Rezoning Petition Review

Rezoning Petition #: 20-138

Location of Property: Approximately 0.47 acres located along the south side of Rutgers Ave, the east side of Ligustrum St and west of Sugar Creek Rd.

SITE PLAN

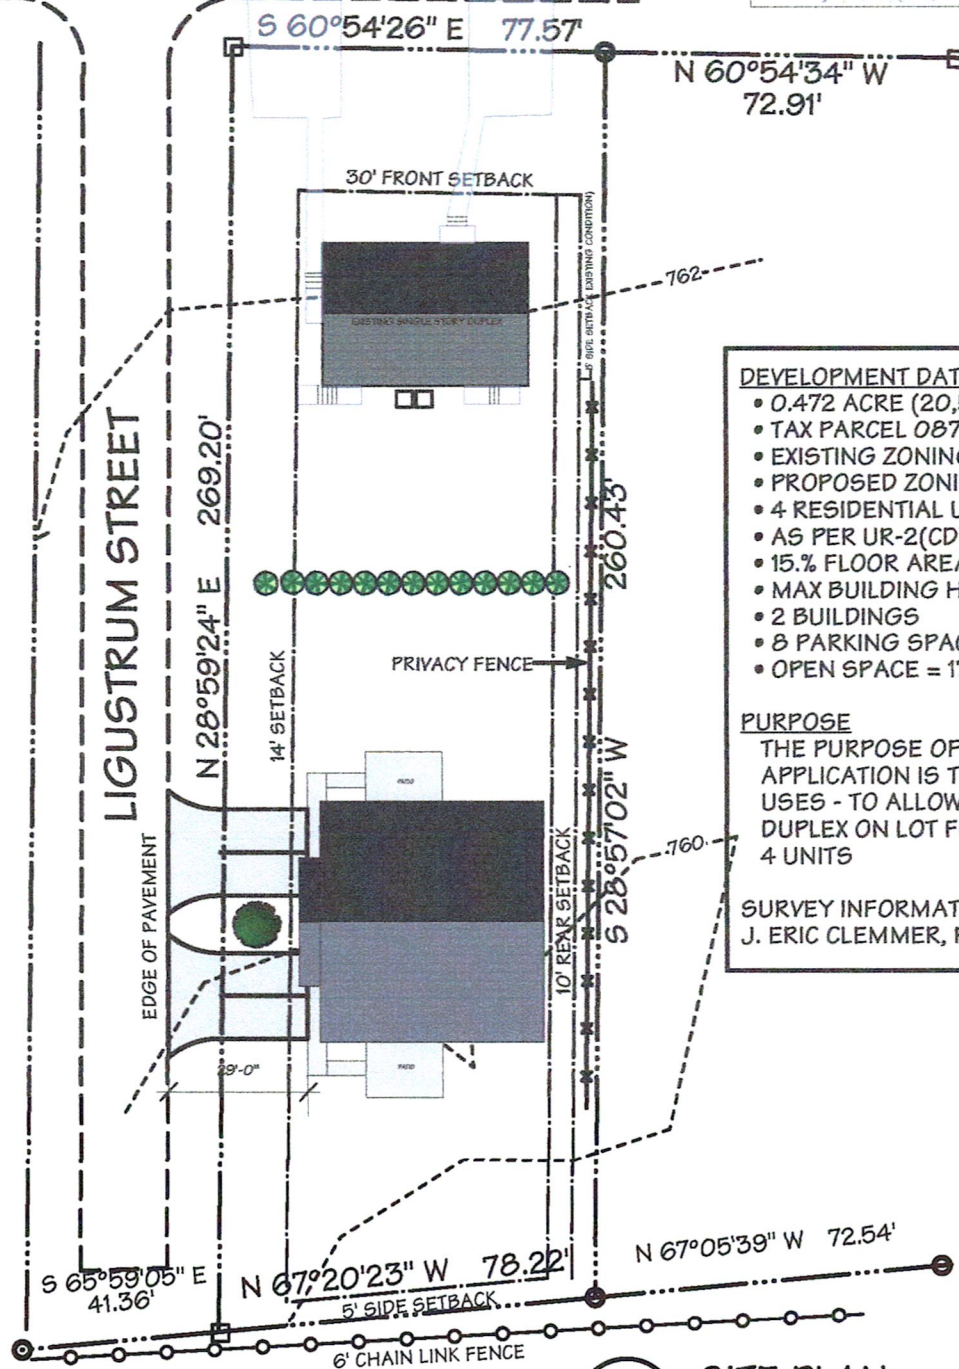
This property drains to Upper Little Sugar Creek, which is an impaired/degraded stream, and may contribute to downstream flooding. This project has the opportunity to mitigate future impacts to this stream, therefore, Storm Water recommends placing the following notes on the plan:

For defined watersheds greater than 24% built-upon area (BUA), construct water quality stormwater control measures (SCMs) designed for the runoff generated from the first 1-inch of rainfall for all new and redeveloped BUA associated with the project. SCMs must be designed and constructed in accordance with the Charlotte-Mecklenburg BMP Design Manual.

For defined watersheds greater than 24% built-upon area, control the entire volume for the 1-year, 24-hour storm for all new and redeveloped BUA associated with the project. Runoff volume drawdown time shall be in accordance with the Charlotte-Mecklenburg BMP Design Manual.

For residential projects with greater than 24% BUA, control the peak to not exceed the predevelopment runoff rates for the 10-year and 25-year, 6-hour storms or perform a downstream analysis to determine whether peak control is needed, and if so, for what level of storm frequency.
